Your Ref: 2020/92657

25th September 2020

Our Ref: W011592

**King James School, St Helen's Gate, Almondbury, Huddersfield – Erection of 10
classroom teaching block and formation of car parking area with associated
engineering and landscape works**

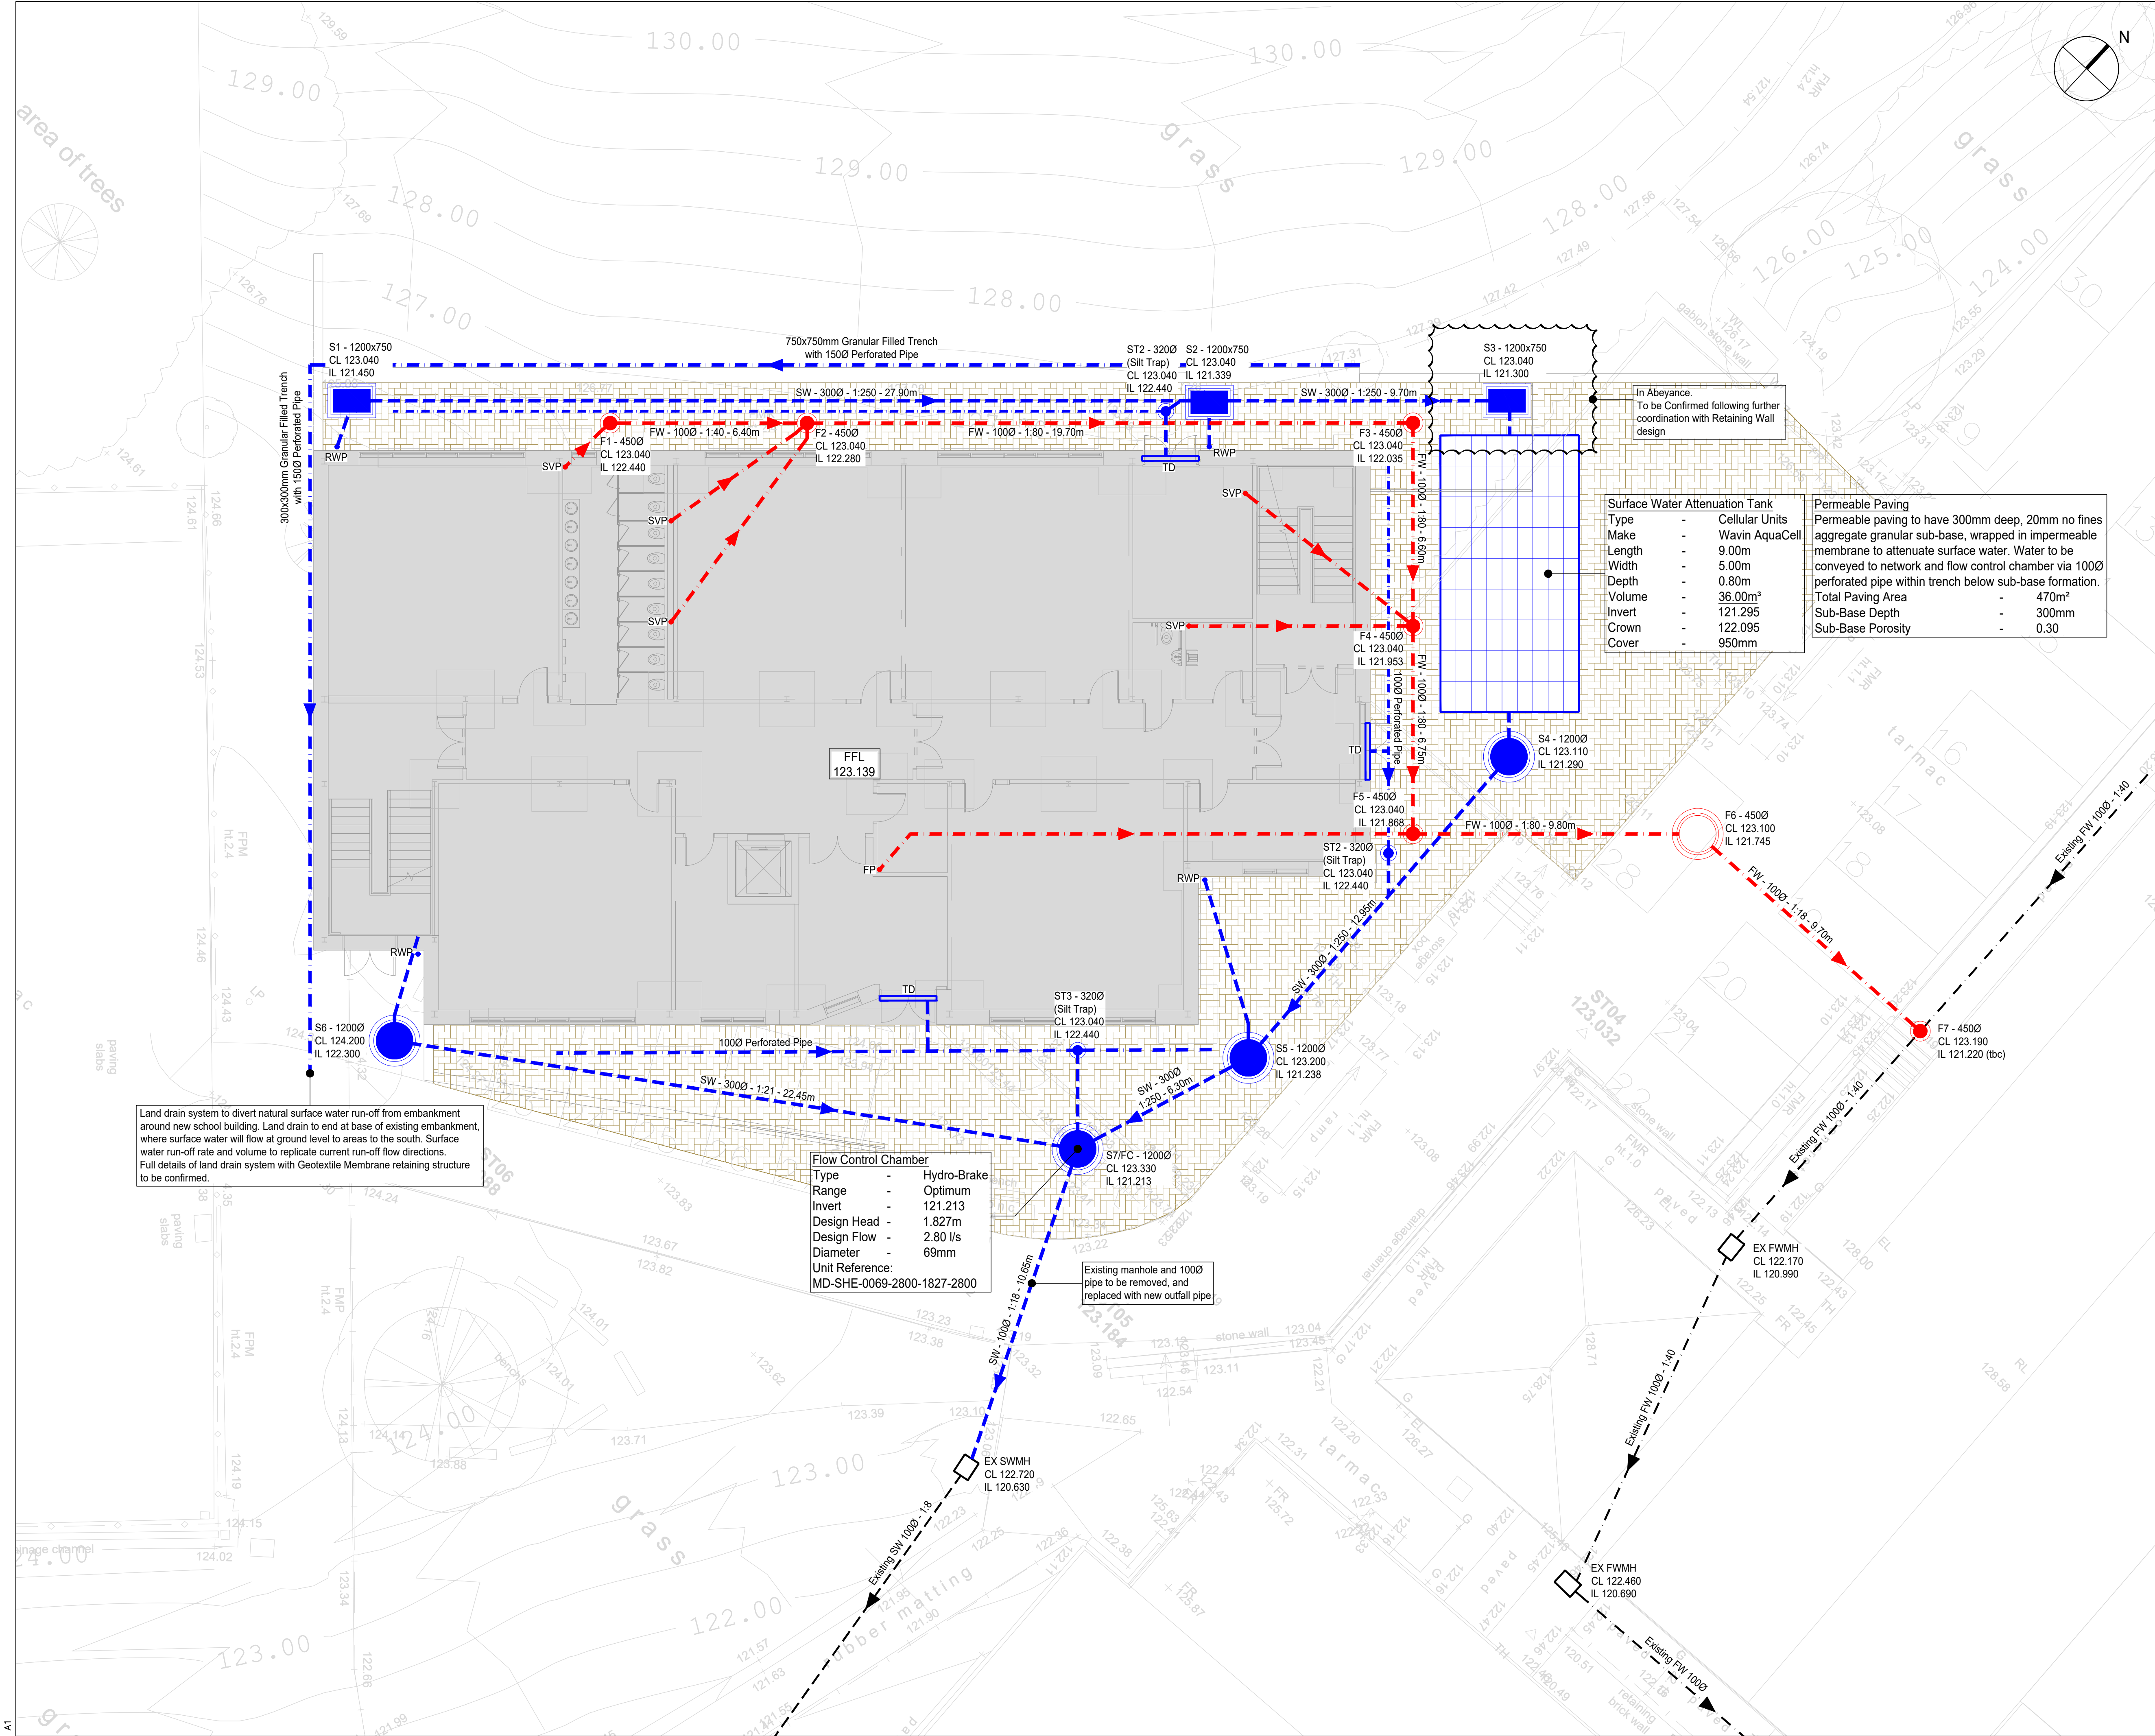
Whilst we have no objections to these proposals, the submitted drawing within the report (LE-020/A1/100 revision P1, dated April 2020) indicates the use of perforated pipes which ultimately discharge to the public surface water sewer network, which is unacceptable.

We fully endorse the use of SuDS however, the public sewer network is for domestic sewage purposes. This generally means that surface water from the roofs of buildings, with surface water from paved areas of land appurtenant to those buildings shall only discharge to the public sewer network. The use of perforated pipes will introduce ground water (land drainage) to the public sewer network; land drainage has no right of connection to the public sewer network. This matter can be addressed at the later stages of this application when the relevant imposed conditions are to be discharged.
